JUDGE ORR RANCHETTES

CONSTRUCTION DOCUMENTS

CONSTRUCTION DRAWINGS

PCD FILE NO.
SP-17-021

JUDGE ORR RANCHETTES
STREET IMPROVEMENT PLAN & PROFILE

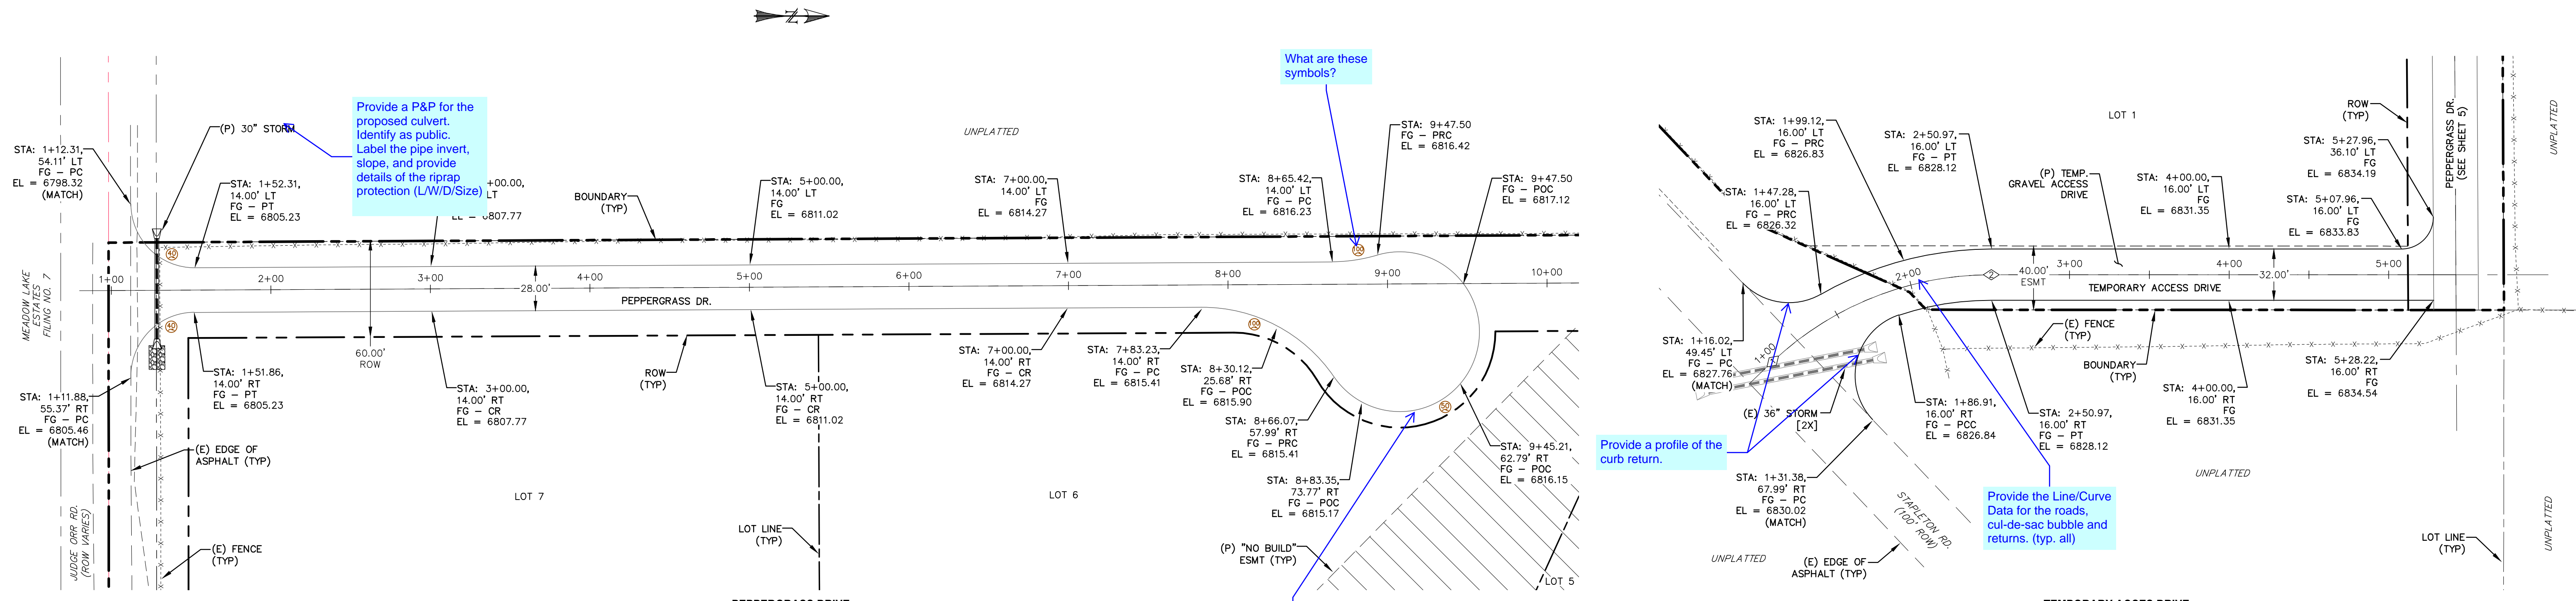
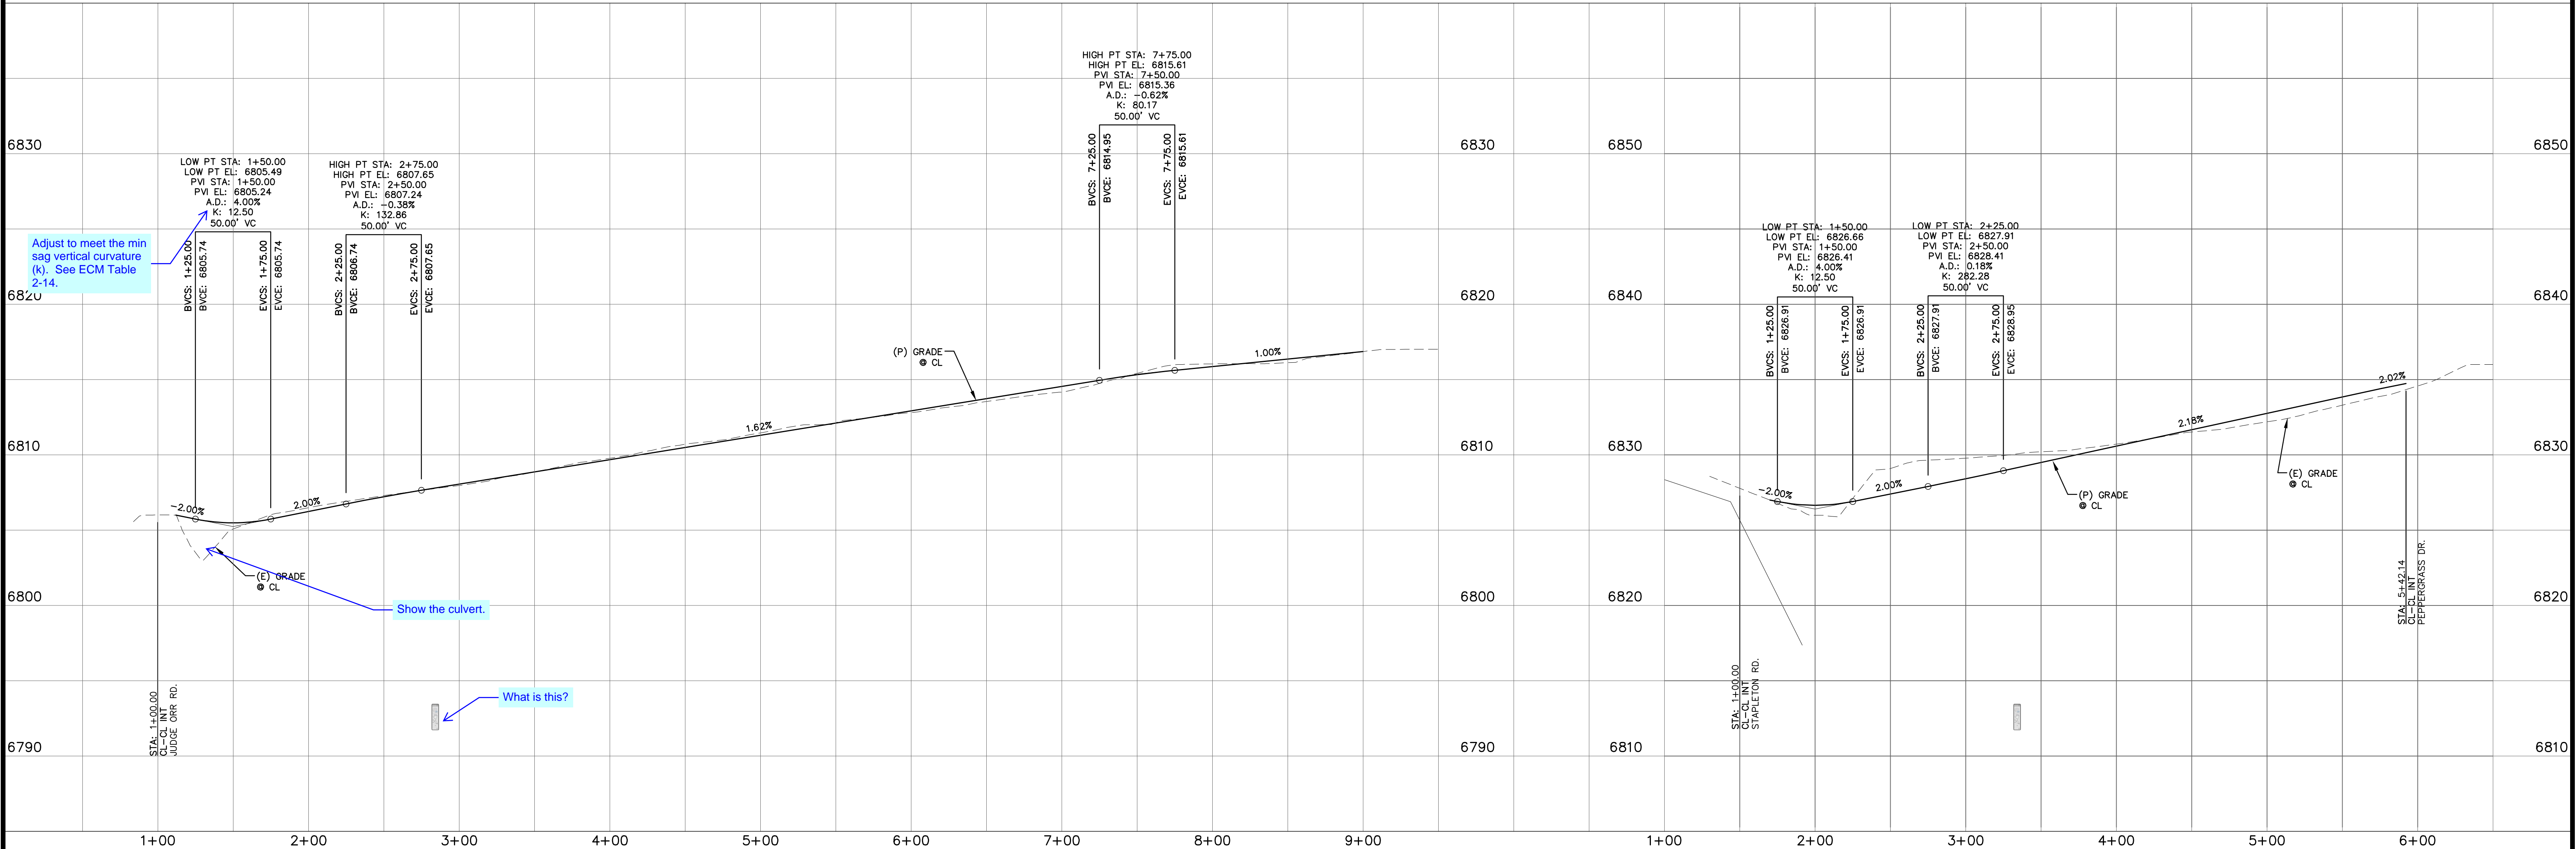
Replace with a curve table which include radius, length, and delta. If curves aren't tangent you may need to include chord bearing.

vertical curves are not required when the algebraic difference in grade is less than 1.0% (ECM 2.3.4.E)
